From: Emily Morgan
Sent: Friday, September 9, 2022 9:13 AM
To: 'Rochelle Smith'; Ryan Larsen
Cc: Chris Holland
Subject: White Barn Dental - PA22-029 - 2nd Review Comments
Attachments: Civil.pdf; PA22-029 White Barn Dental 8813 Soper Hill Road 8-30-2022.pdf

RE: White Barn Dental, File# PA22-029
New Dental Office
8833 Soper Hill Rd & Parcel # 00590700031800

PA22-029

Re: **Project Name:** White Barn Dental

TITANIUM OFFICE, LLC
DENTAL OFFICE - WHITE BARN
PRELIMINARY SITE PLAN

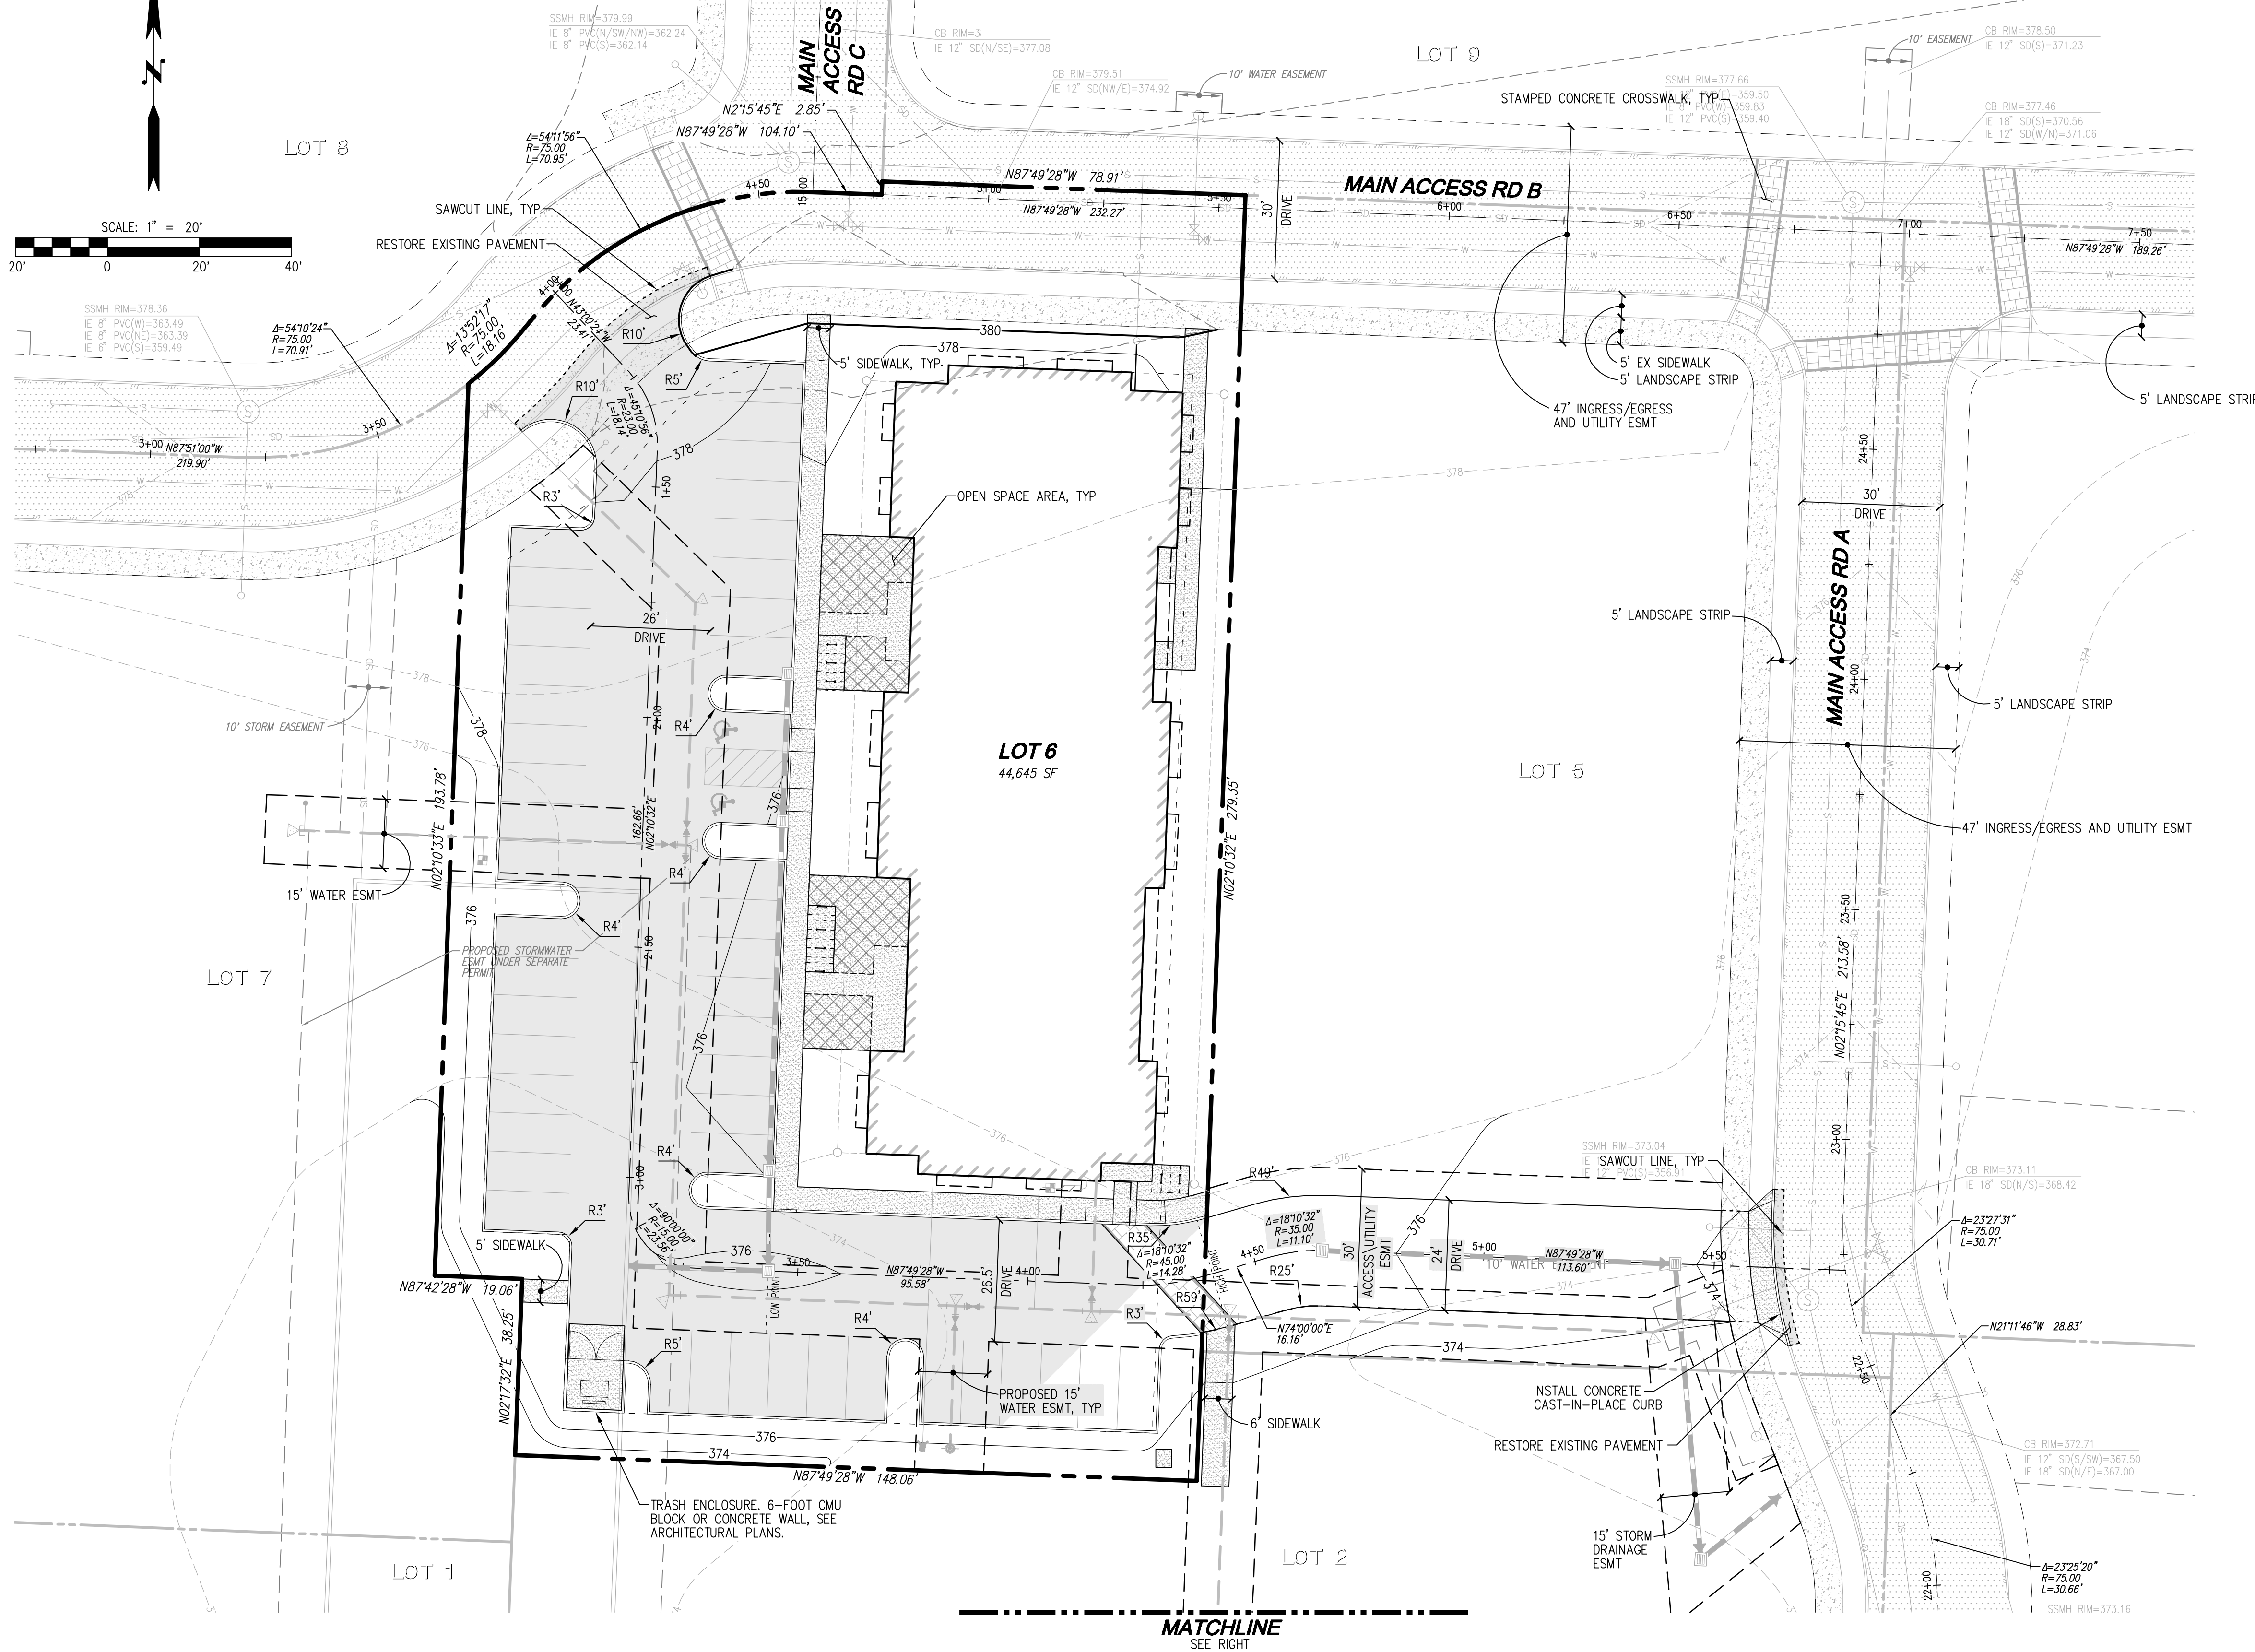
- c. The minimum width of a commercial driveway is 24-feet and the maximum is 40-feet.
2. **Drainage:** All projects in the city of Marysville must comply with requirements stipulated under the MMC 14.15.040 and 14.15.050.

- b. A geotechnical report has been provided.
 - c. The maximum allowed impervious surface coverage for the Zoning designation is 85%. Please confirm if the current proposal meets this ratio.
